# **KITITAS COUNTY**

### **MEMORANDUM**

TO: All Staff  
FROM: Justin Turnbull, County Surveyor   
DATE: October 17, 2017  
SUBJECT: County Survey review of Boundary Line Adjustment 17-00009 (Buildworx)

LOTS C & D, BLOCK 9
VILLAGE AT THE SUMMIT, DIVISION II
 LOCATED IN THE SW 1/4, SEC. 4, T. 22 N., R. 11 E., W.M.

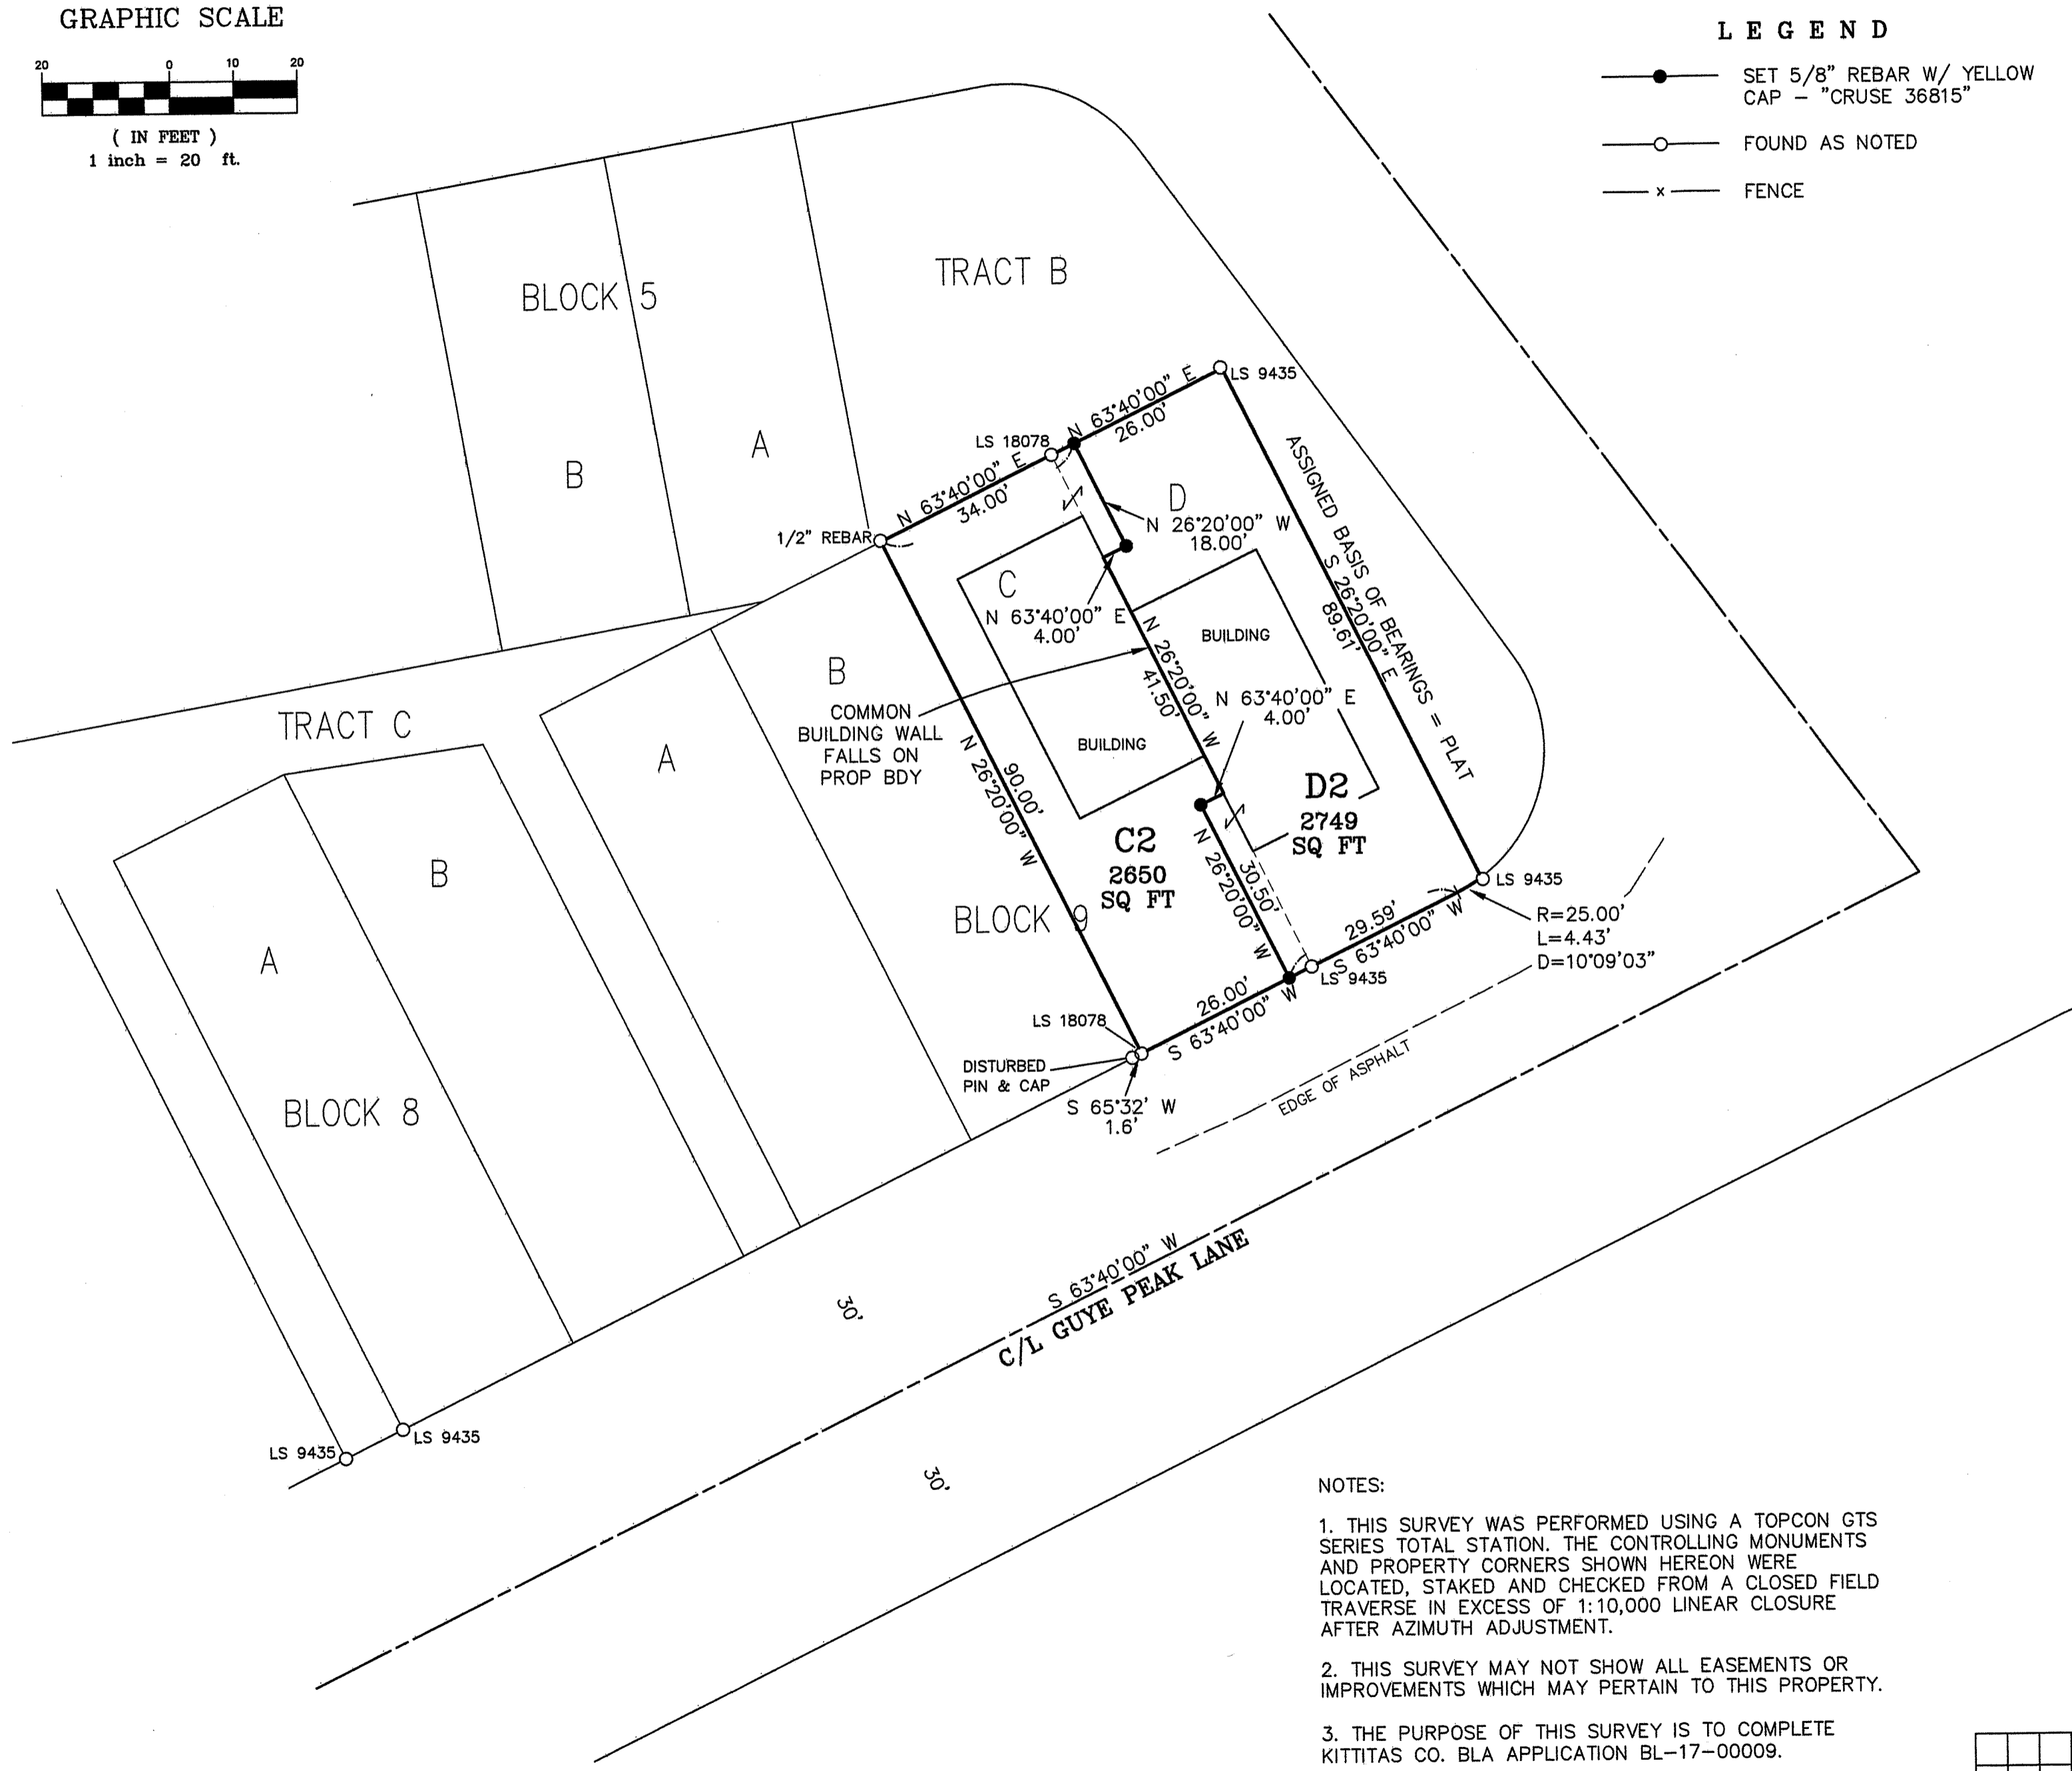
1. All tied corners should include distance ties on the face of the map.
